KITTITAS COUNTY

MEMORANDUM

TO: Jeff Watson, CDS
FROM: Christina Wollman, Planner II *CW*
DATE: January 16, 2013
SUBJECT: Arnott BL-12-00034

The Public Works Department has reviewed the Request for Boundary Line Adjustment and finds that it meets current Kittitas County Road Standards.

BOUNDARY LINE ADJUSTMENT SURVEY

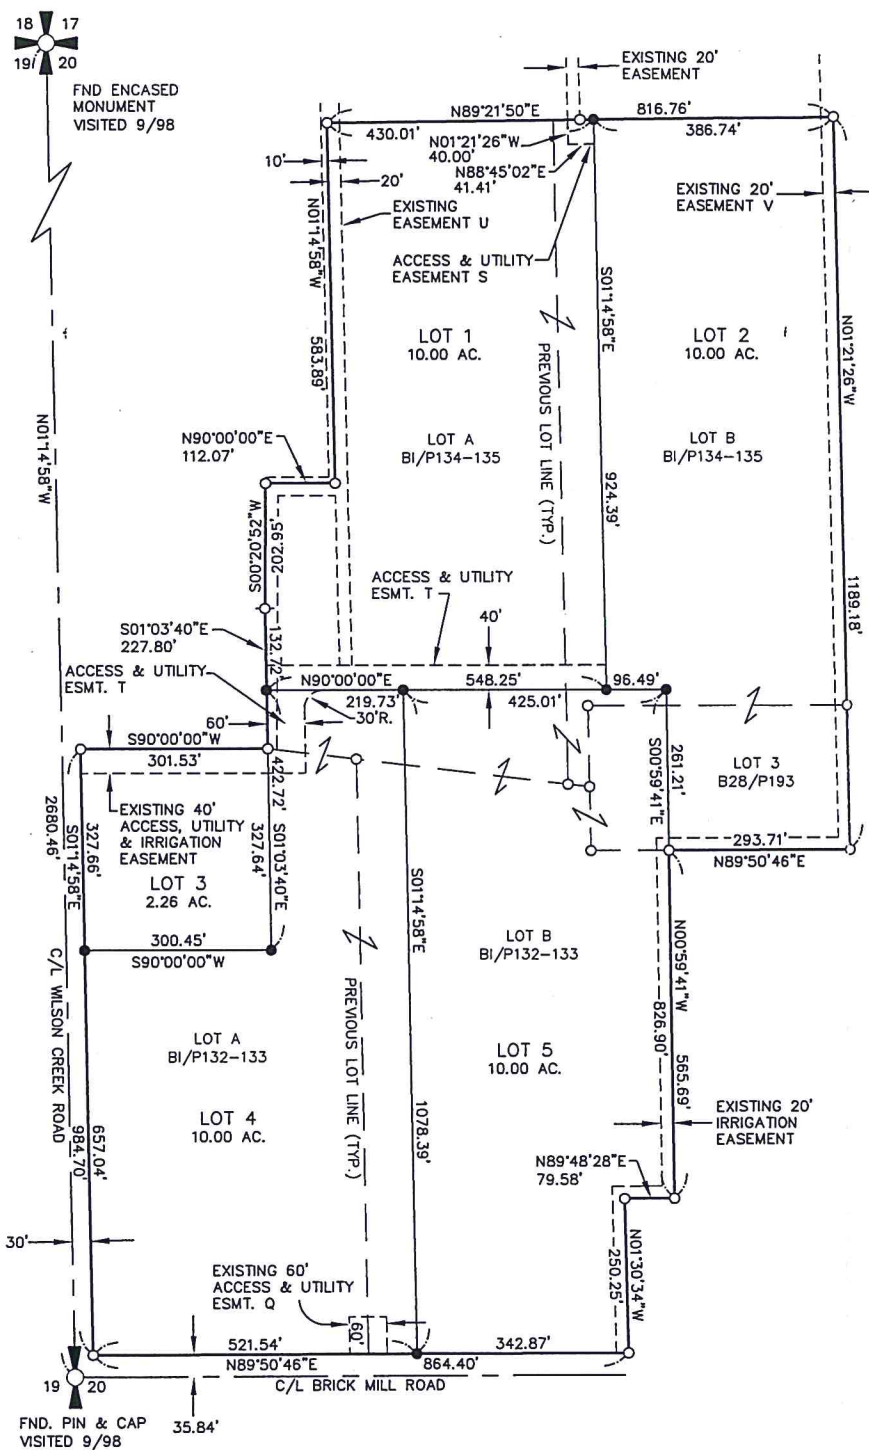
- a. An easement for a cul-de-sac shall be established at a point on the 40' easement where two or less lots are served.
- b. Road construction standards for lots 1, 2, 4 and 5 will remain the same as required in the Boddy Short Plat SP-05-17 and the R. Arnott Short Plat SP-05-96 with the addition of the cul-de-sac. The road and cul-de-sac must be constructed or bonded for prior to issuance of an occupancy permit for the Boddy Short Plat and building permit for the R. Arnott Short Plat.

- c. Lot 3 must construct an approach off the county road that meets the standards for construction of the 22' wide private road prior to receiving a building permit.

- d. All lots within the BLA must access from the 40' private access easement off Wilson Creek Road.
- e. An approved access permit shall be required from the Kittitas County Department of Public Works prior to creating any new driveway access or performing any work within the county road right of way.
